Response to Planning Application

From: Arun District Council Greenspace

Application ref: A/46/22/RES

Location: Phase 1 - Land off Arundel Road Angmering

Planting Plan - S401
1 of 4

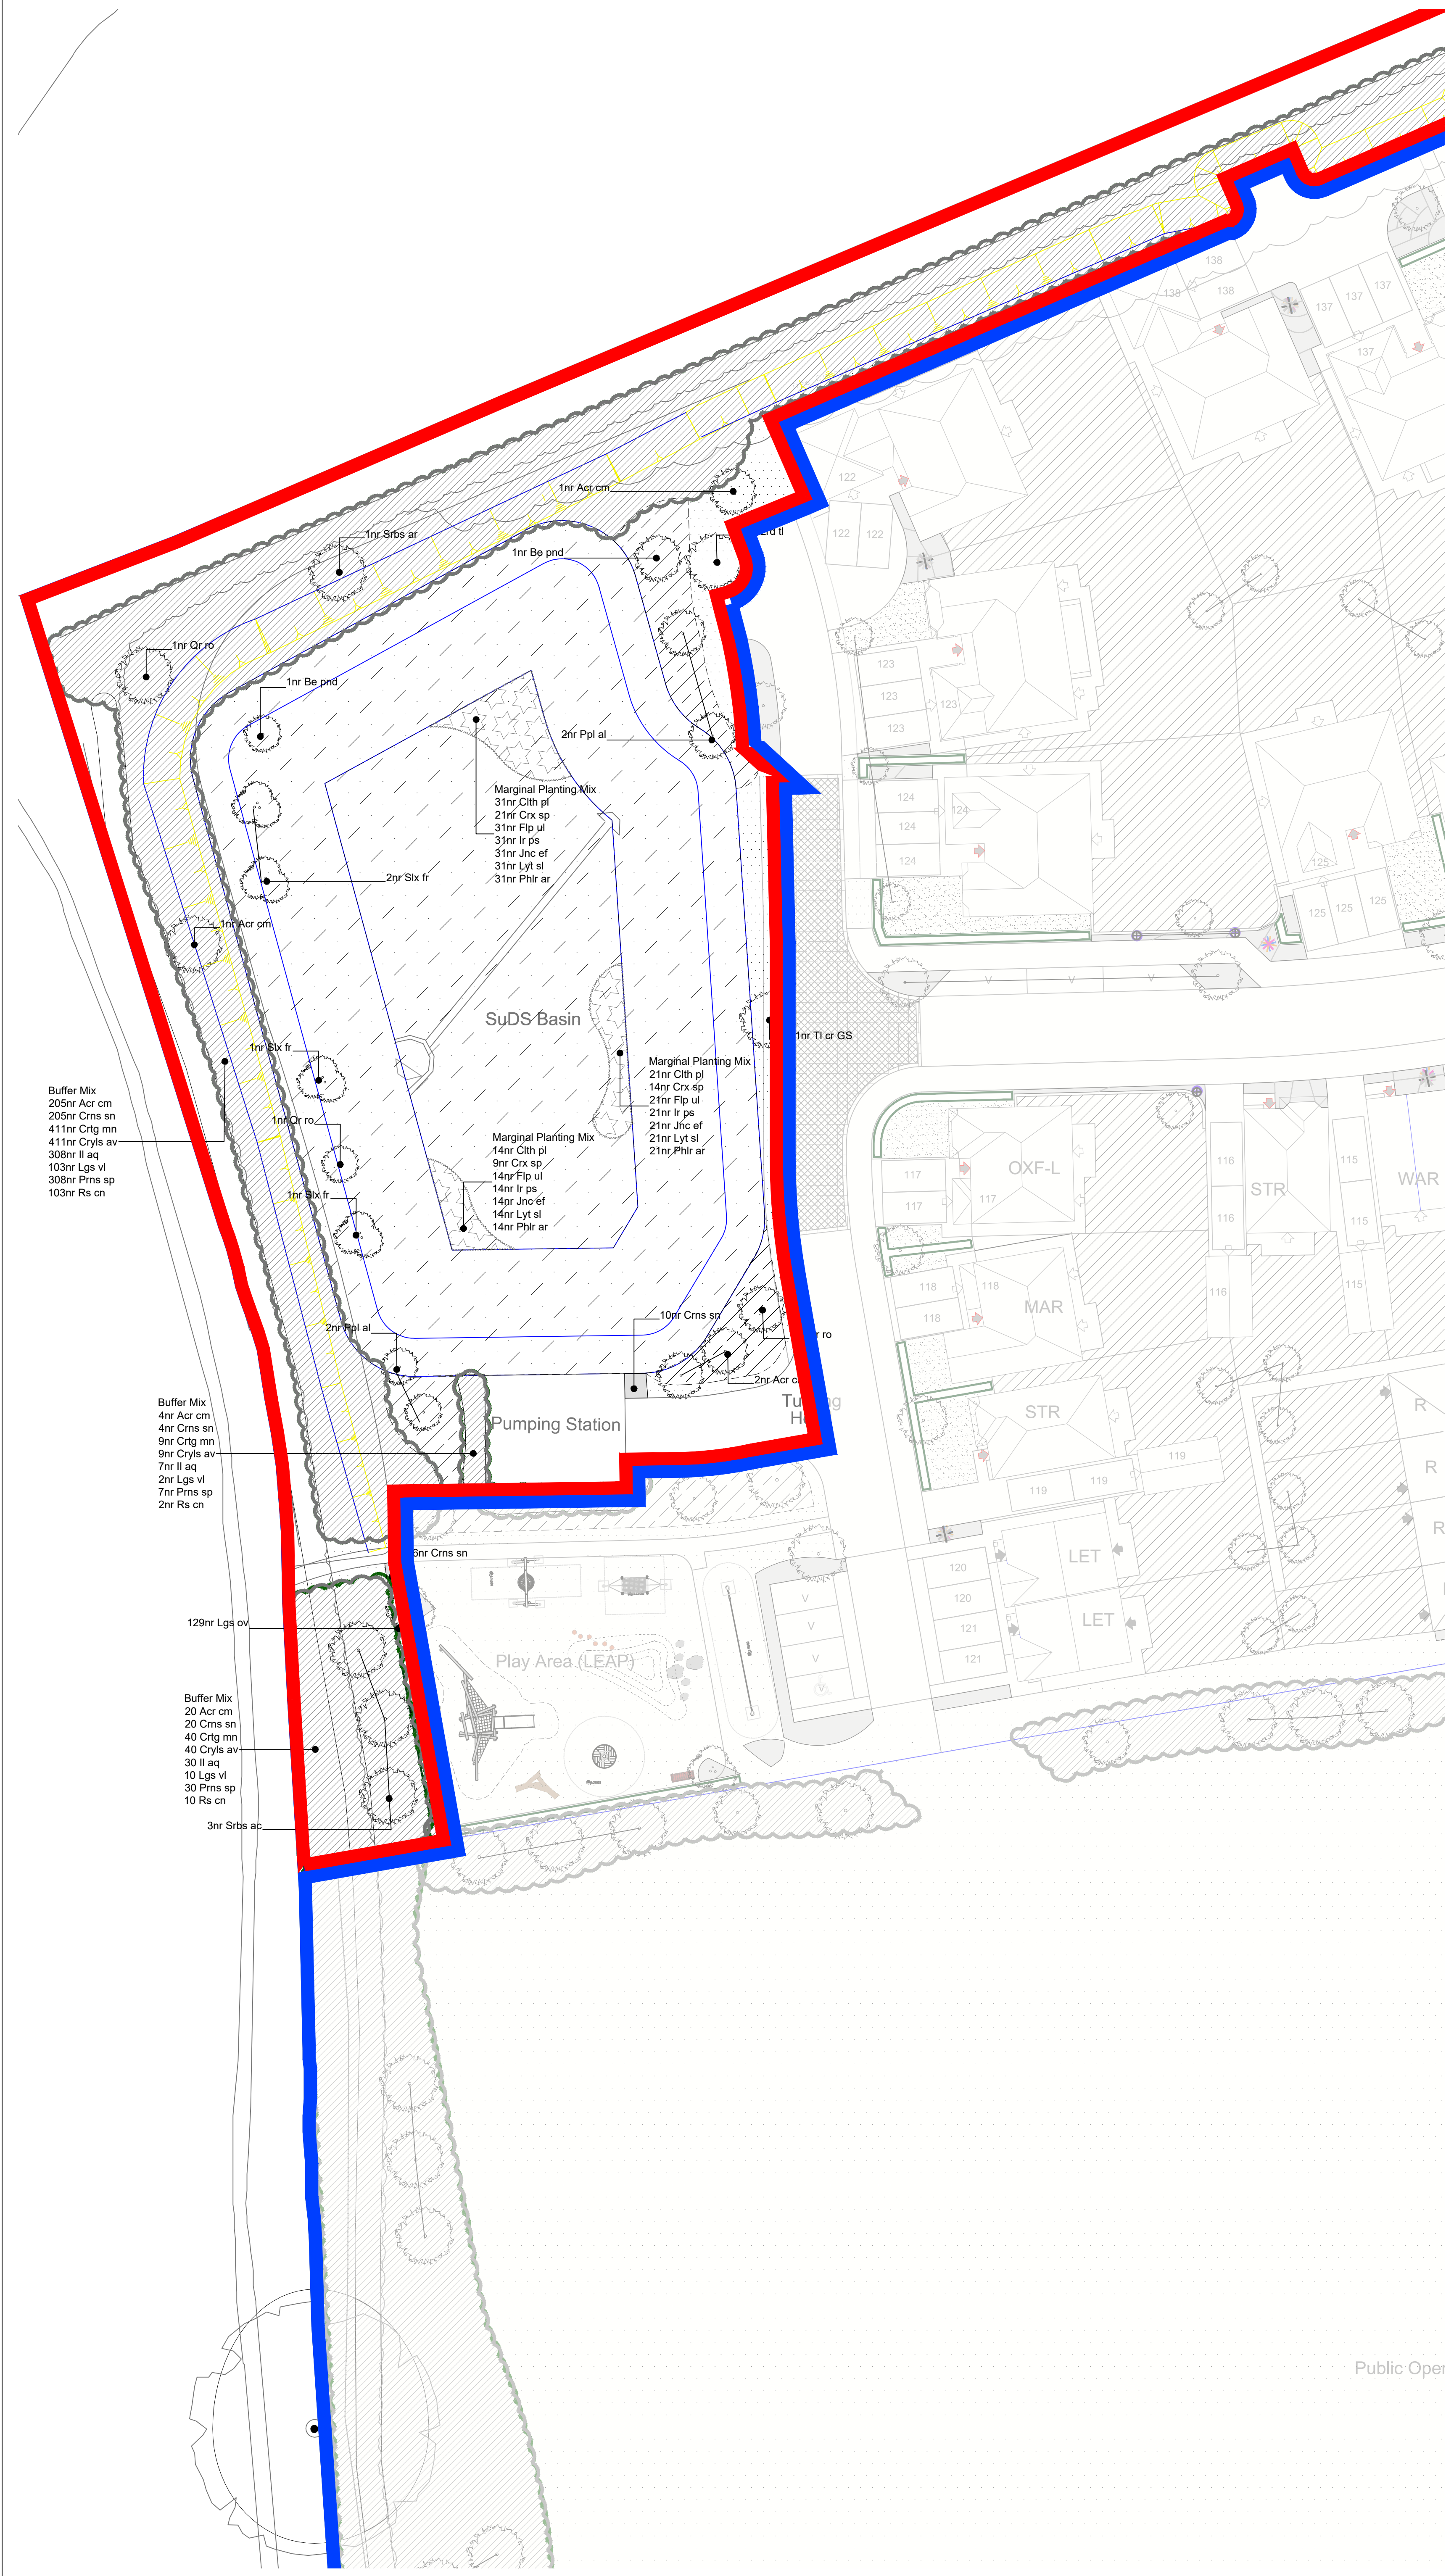
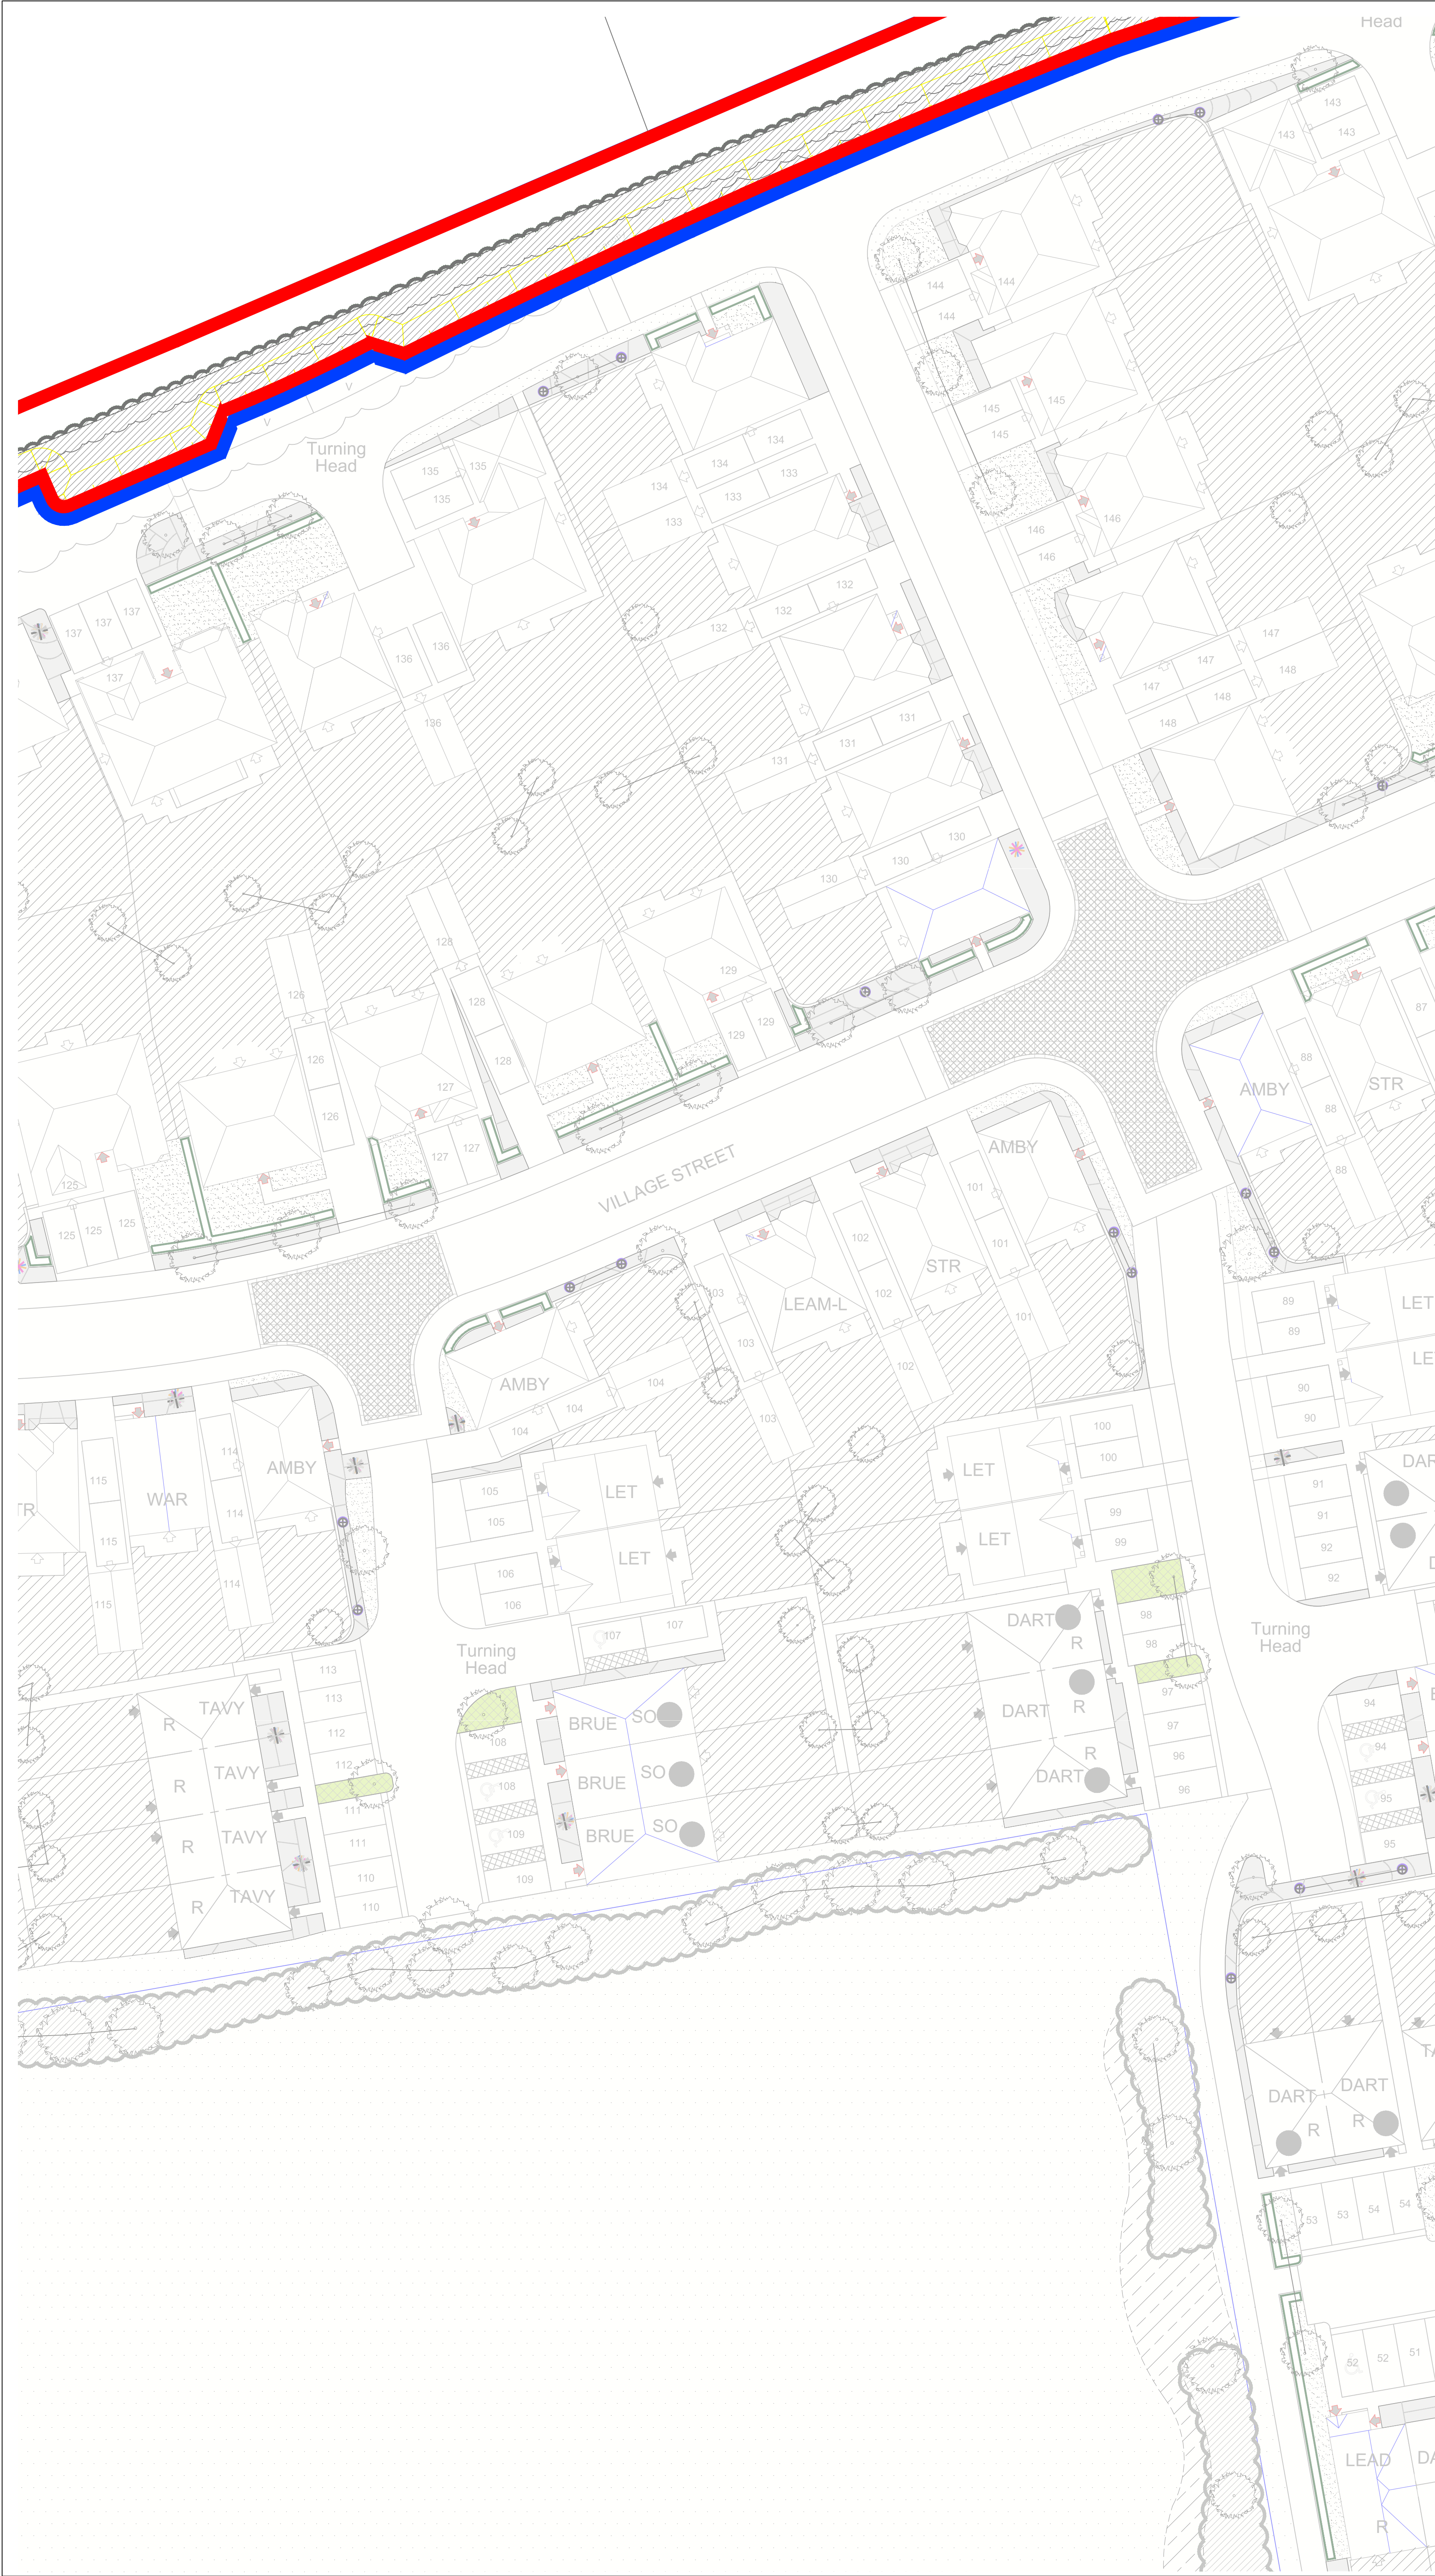
This application has provided landscape detail in the form of a Landscape strategy dwg 120 REV A, Planning and DAS document, Tree and Shrub palette document and detailed Planting Plans 1-4 of 4 Rev's A. Whilst these documents show the picture for this section of the site it does not detail how this will be integrated within the wider site context which is information that should be a consideration.

A full landscape scheme for this red line portion of the site has been submitted; detailing species choice, position, densities and size at time of planting. This has been plotted in plan and list form and in relation to the trees and vegetation to be retained, however the wider context landscaping is yet to be submitted and therefore full backing of the proposals could not be made until the wider context and integration of both has been made.

Recommend that the landscape context of the wider site is considered including all areas of POS and buffer planting. Recommend that the outline application is considered re the entrance POS to ensure that the site is not compromised by the depletion of the green buffer in this location.
